CITY OF ALBUQUERQUE

September 22, 2022

Sites: Coors Pavilion Subdivision – 4111 Coors Blvd NW - G11E069

Re: Drainage Ordinance (14-5-2-11) Violations for Erosion and Sediment Control

AMENDMENT FOR MASTER DRAINAGE PLAN

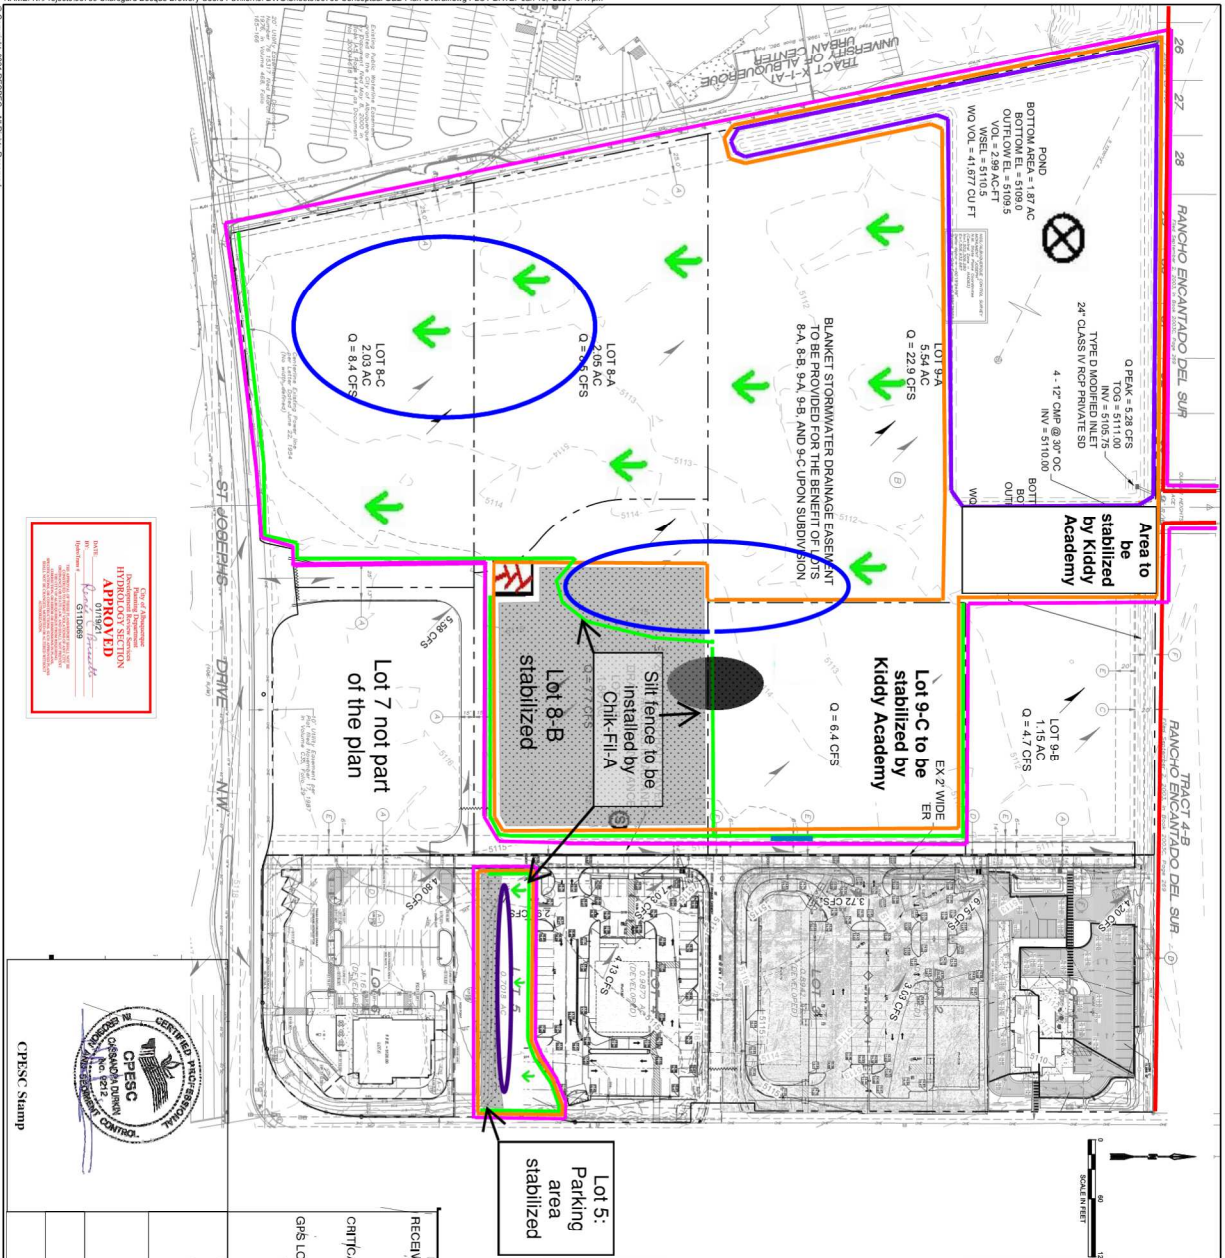
3. The SWPPP wasn't up-to-date. Inspection Reports or Corrective Action Reports weren't available, and the SWPPP Map doesn't show current site conditions.

6. Lots 8C and 9C are still covered by mostly bare dirt, but a small area near Chick-fil-a was recently covered with gravel. The stockpiles are bare dirt and are not covered as required by CGP 2.2.14.

3. The SWPPP must be kept up-to-date per CGP 7.1.
 - a. The SWPPP Map was prepared under a previous version of this permit, so the operator must review and update the SWPPP to ensure that the CGP requirements are addressed per CGP 7.1. The information required by the CGP is the minimum that must be contained in the SWPPP per CGP 7.2. The SWPPP map must include:

- i. Boundaries of the property owned by the operator per CGP 7.2.4a
 - ii. Locations where earth disturbing activities will (or have already) occur per CGP 7.2.4.b.i

- iii. Locations of stockpiles per CGP 7.2.4b.iii
 - iv. The projected schedule for stormwater control installation/implementation per CGP 7.2.6a.iv
 - v. **Stabilization measures** including specific vegetative and non-vegetative practices that will be used per CGP 7.2.6b.vi

4. BMPs – Silt fence must be reset according to a new plan that identifies all disturbed areas, stockpiles, and the current property boundaries.
5. Where sediment has been tracked-out from your site onto paved roads remove the deposited sediment by the end of the same business day CGP 2.2.4.d,
